Representations re - Planning Application: 3/2021/1262

Thank you for the notification of the Application by [REDACTED] to build 4 commercial units.

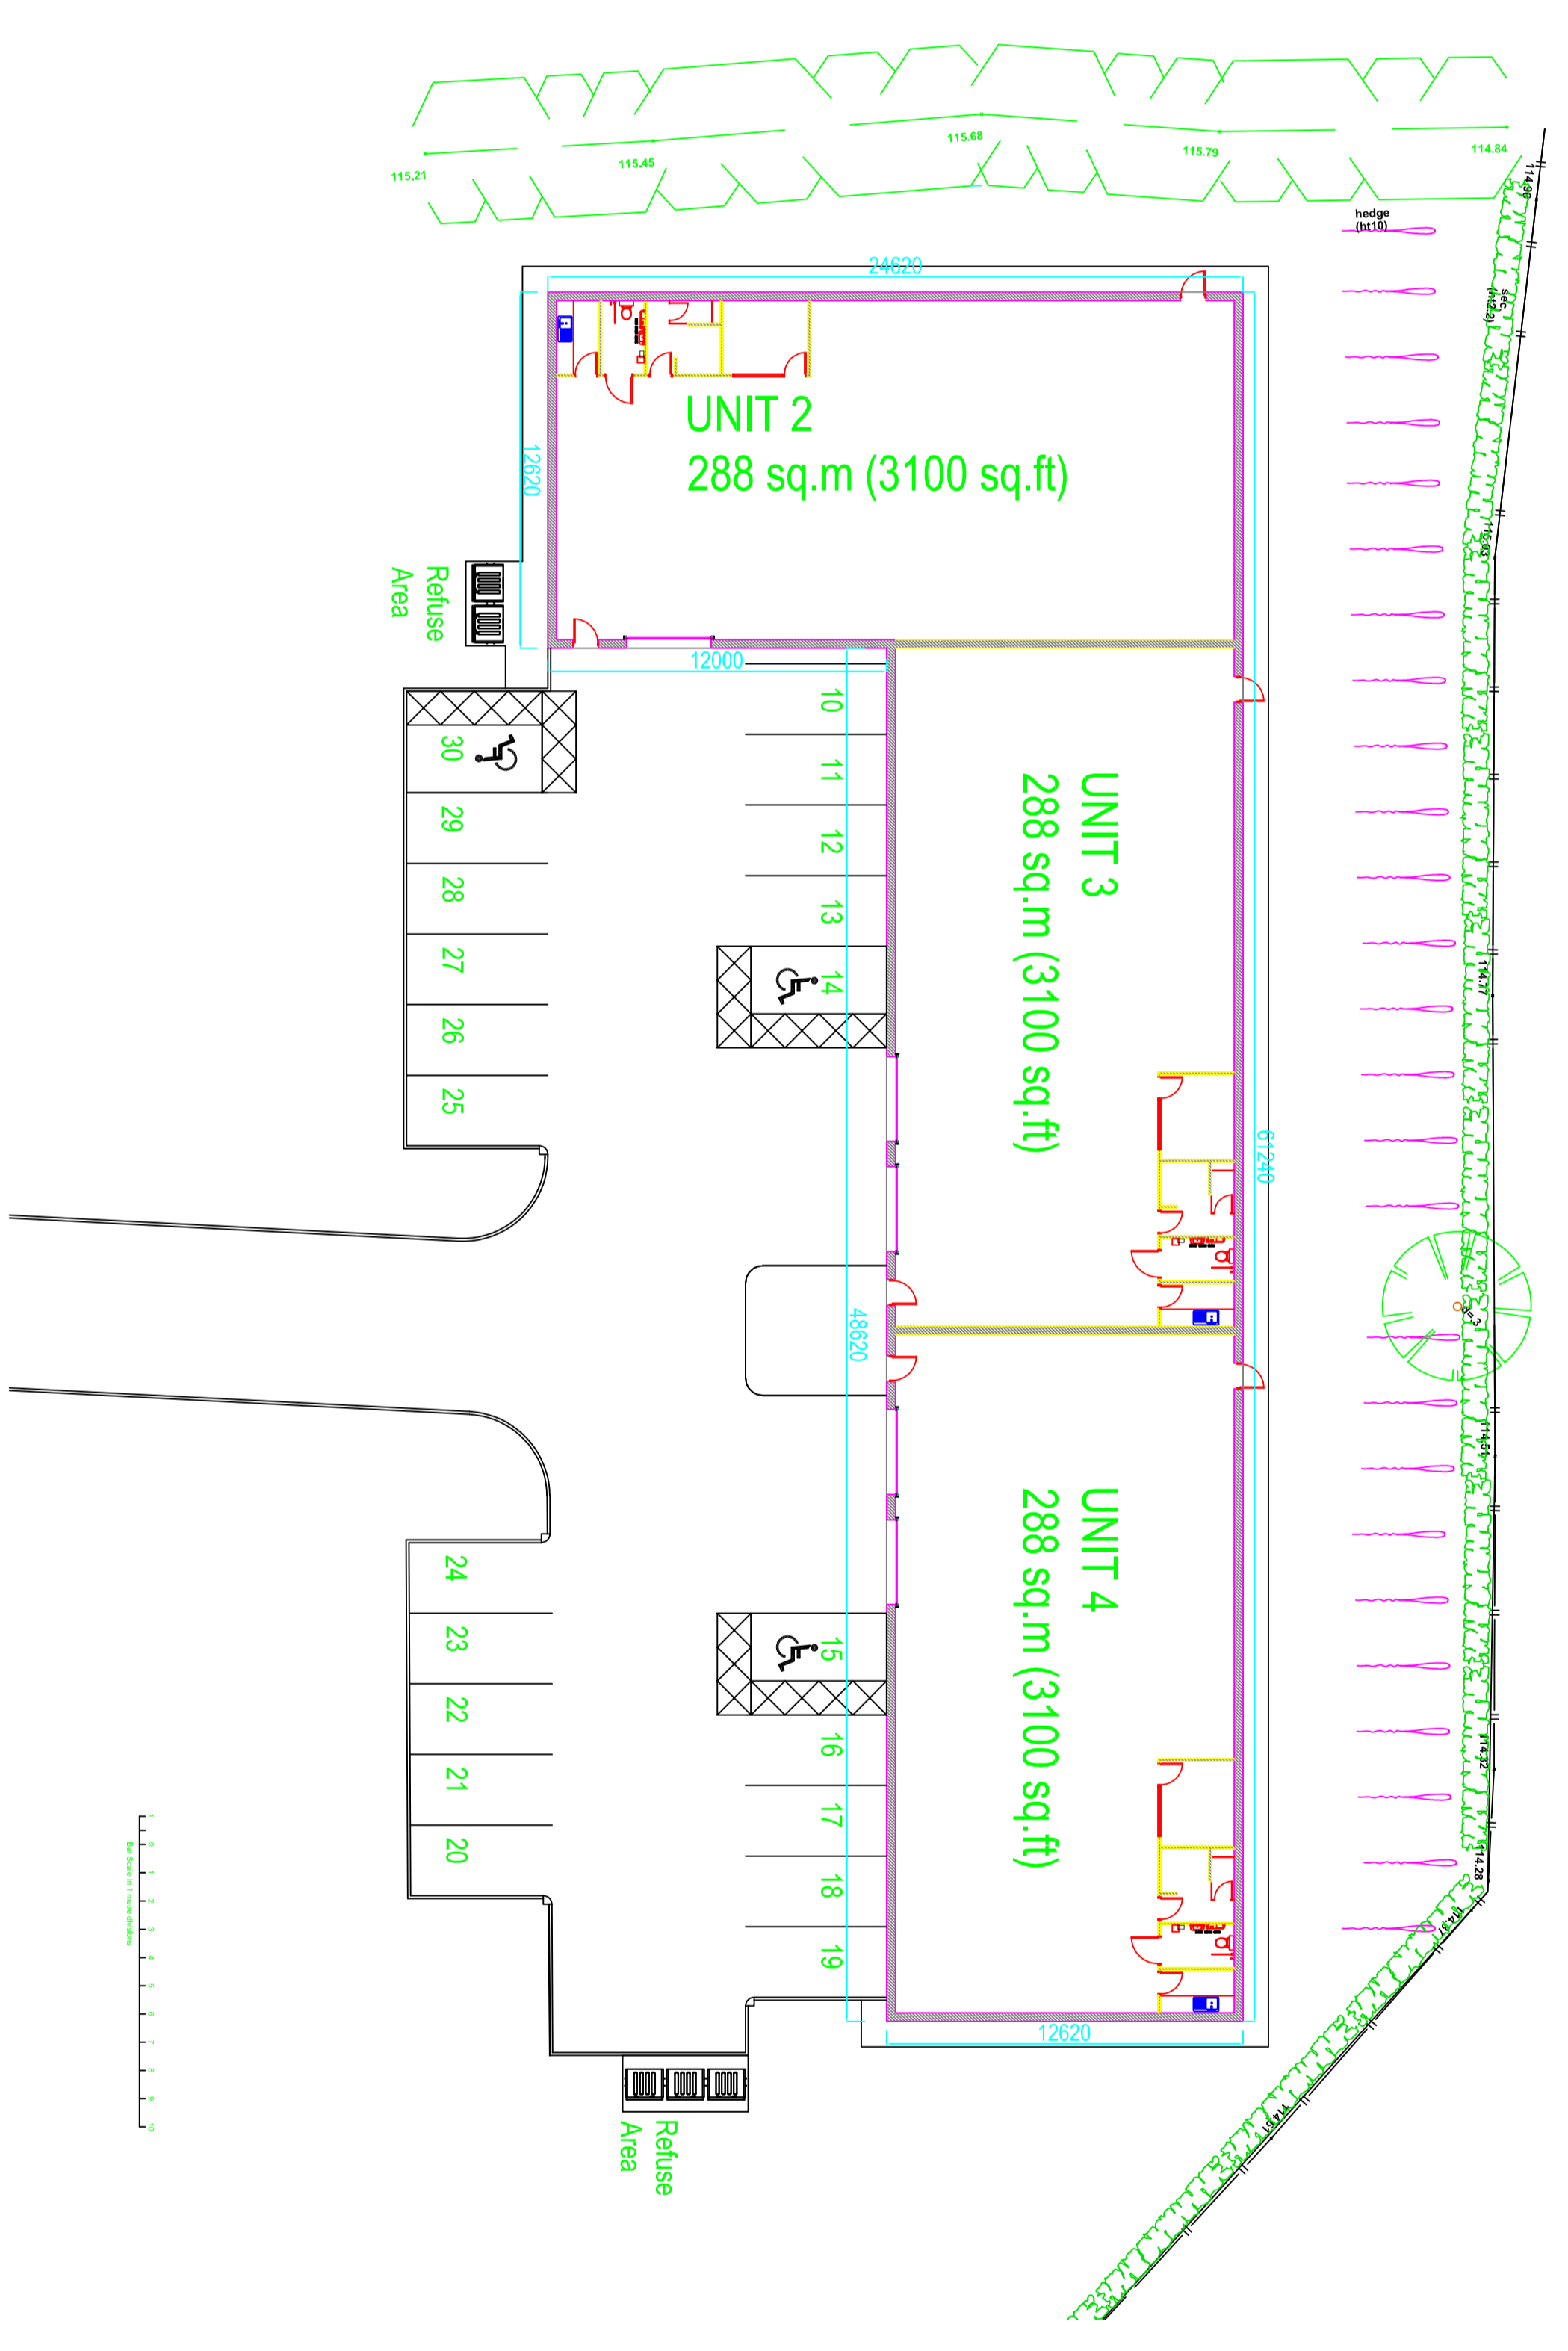
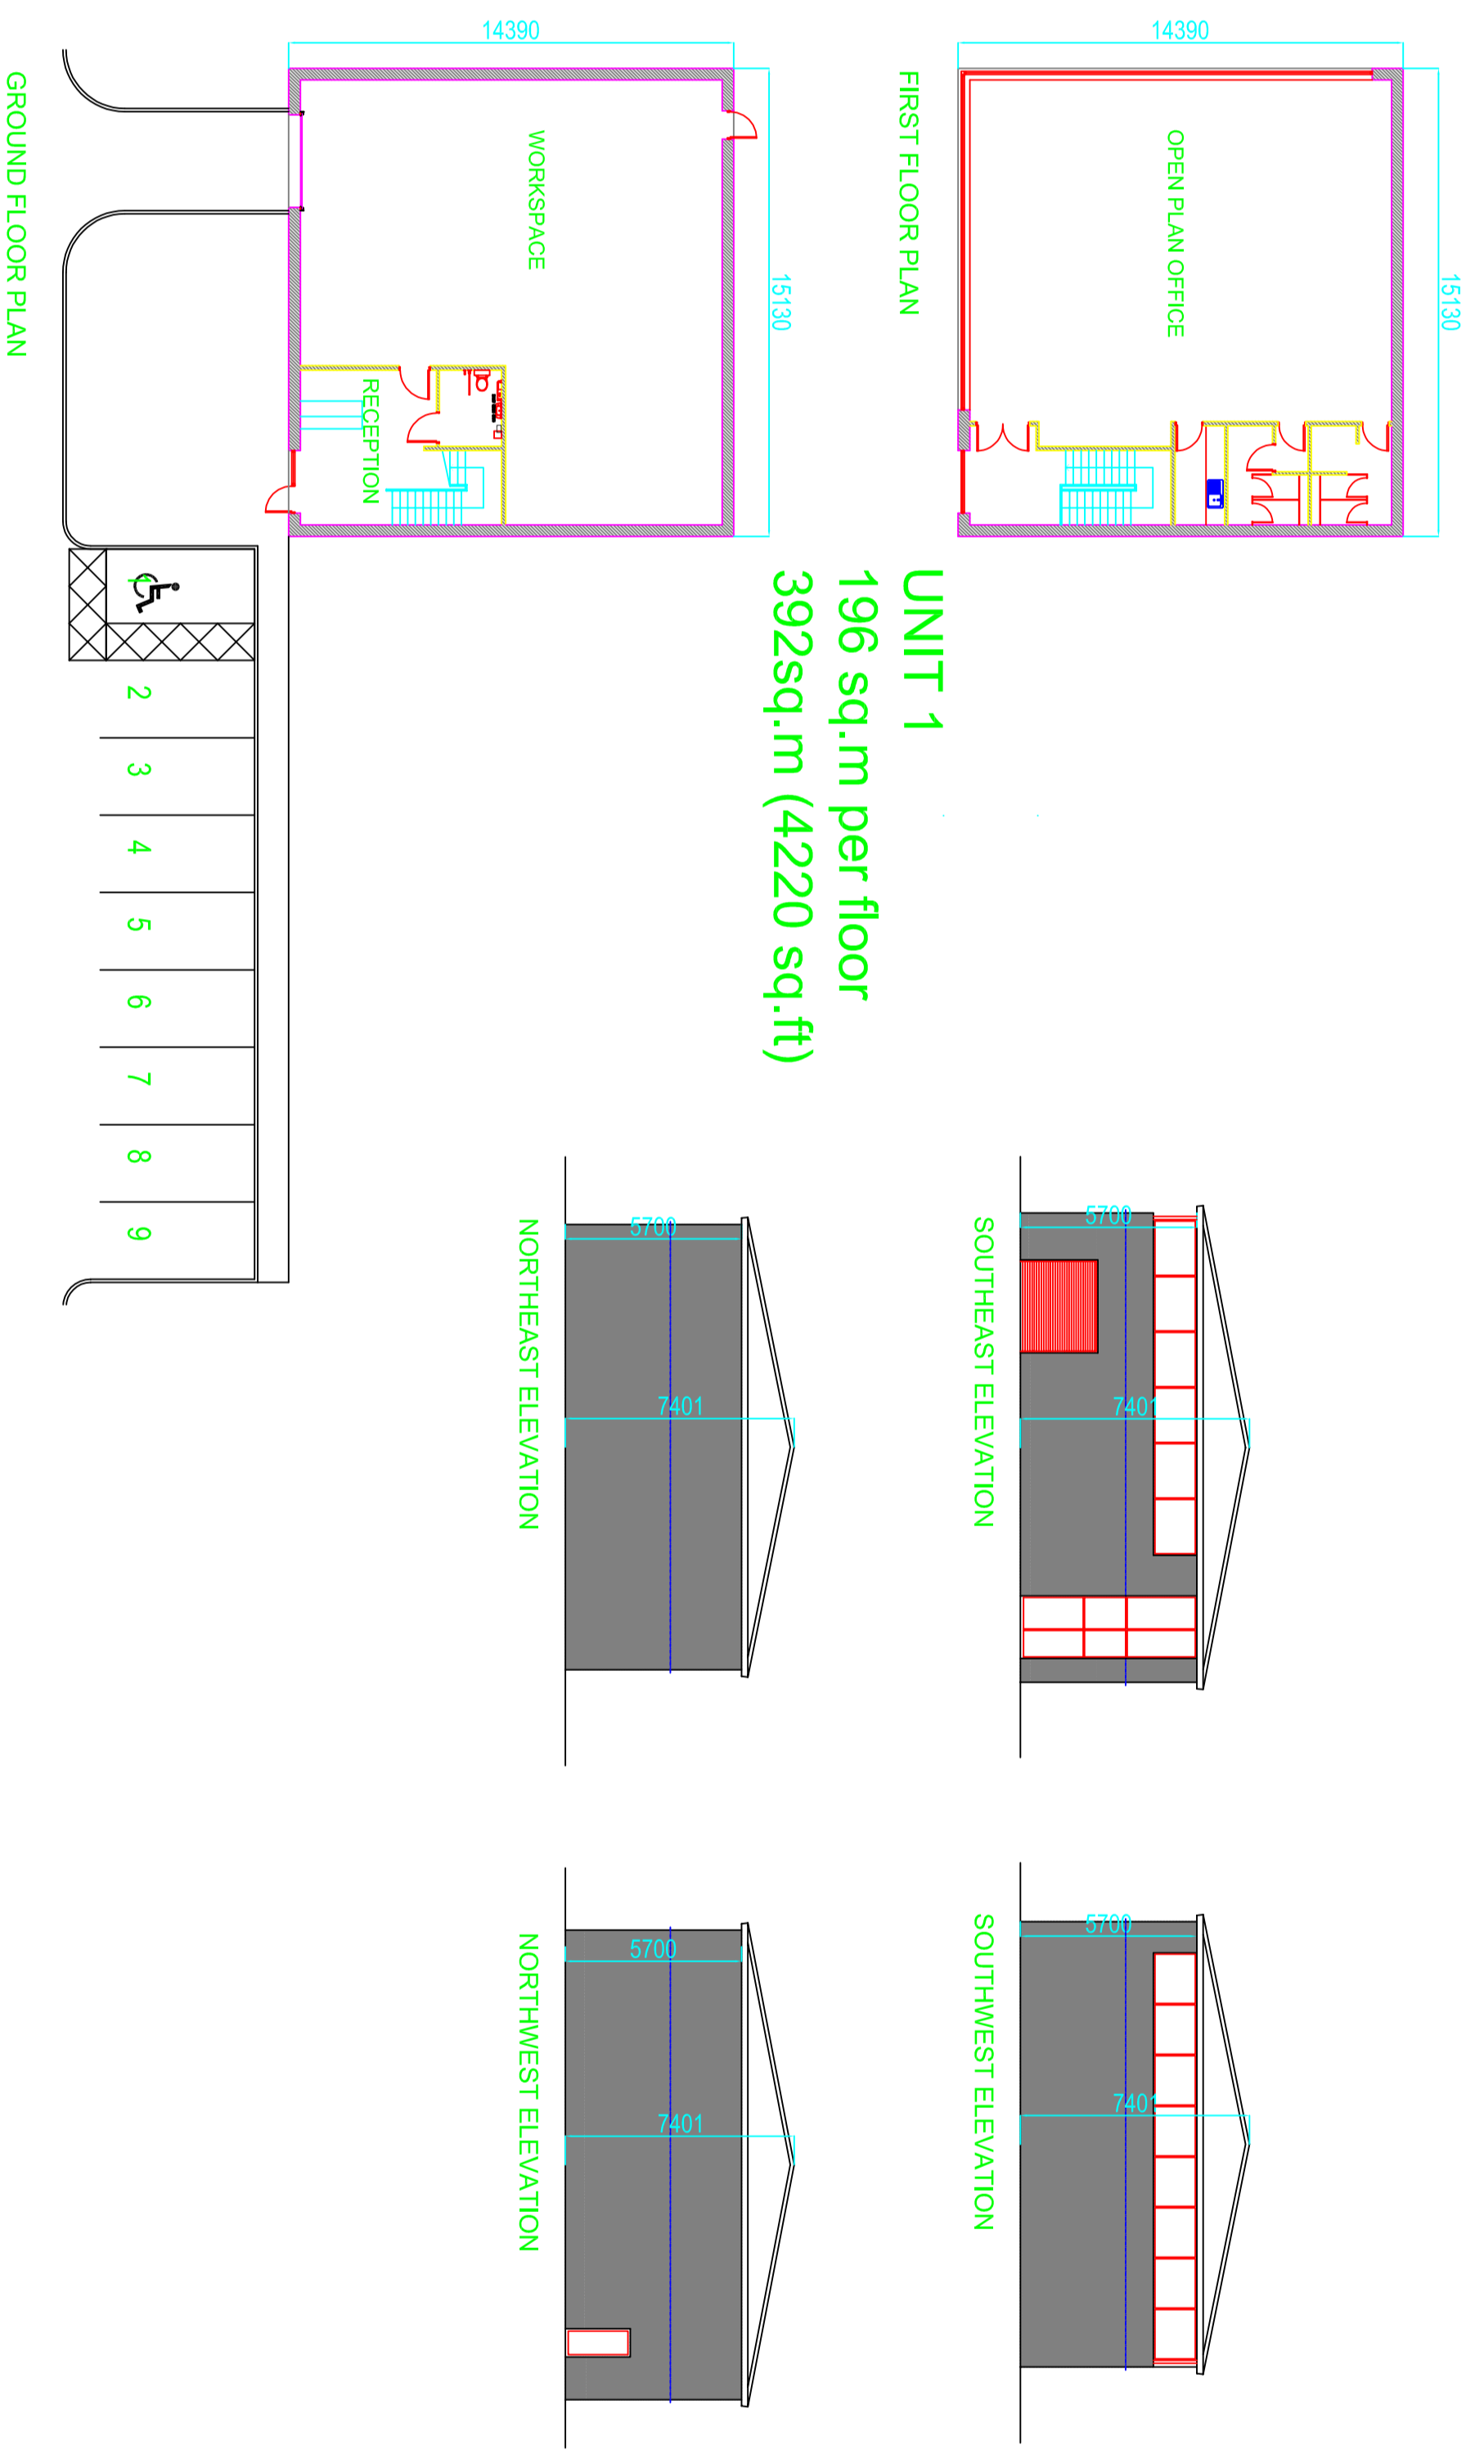
**1. Planning Changes - Lack of consideration for the 'visual pollution' that will be experienced by properties lower down on Chapel Hill.**

I would seek a change to the Plans to include some additional landscaping on the South boundary of the new development to soften the view from properties [REDACTED] Chapel Hill of the front and side elevations of the proposed new development. Much of the proposed landscaping only benefits Little Lane and the School as neighbours, which quite frankly only have limited view of the new development compared to [REDACTED] Chapel Hill.

Due to the 'hill' nature of the bordering Chapel Hill it is unfortunate that the neighbouring [REDACTED] Chapel Hill properties, which sit lower down on Chapel Hill, will be able to see most of the front and side elevations from their rear upper windows whereas the Little Lane neighbours, who have been considered, will only see the roof line out of their rear upper windows. In fact some selective planting of a few new mature trees to replace the numerous mature trees that were previously removed to clear the land for Application 3/2019/0753, at the boundary of [REDACTED] Chapel Hill would also soften the view of the recently completed commercial unit build (Application 3/2019/0573). After all this site borders the Conservation Area and whilst I am sure we all acknowledge the importance of commercial development it is important that the overall 'feeling' of the Conservation Area should be preserved for the good of Longridge.

Please see below for suggested areas for some more soft landscaping.
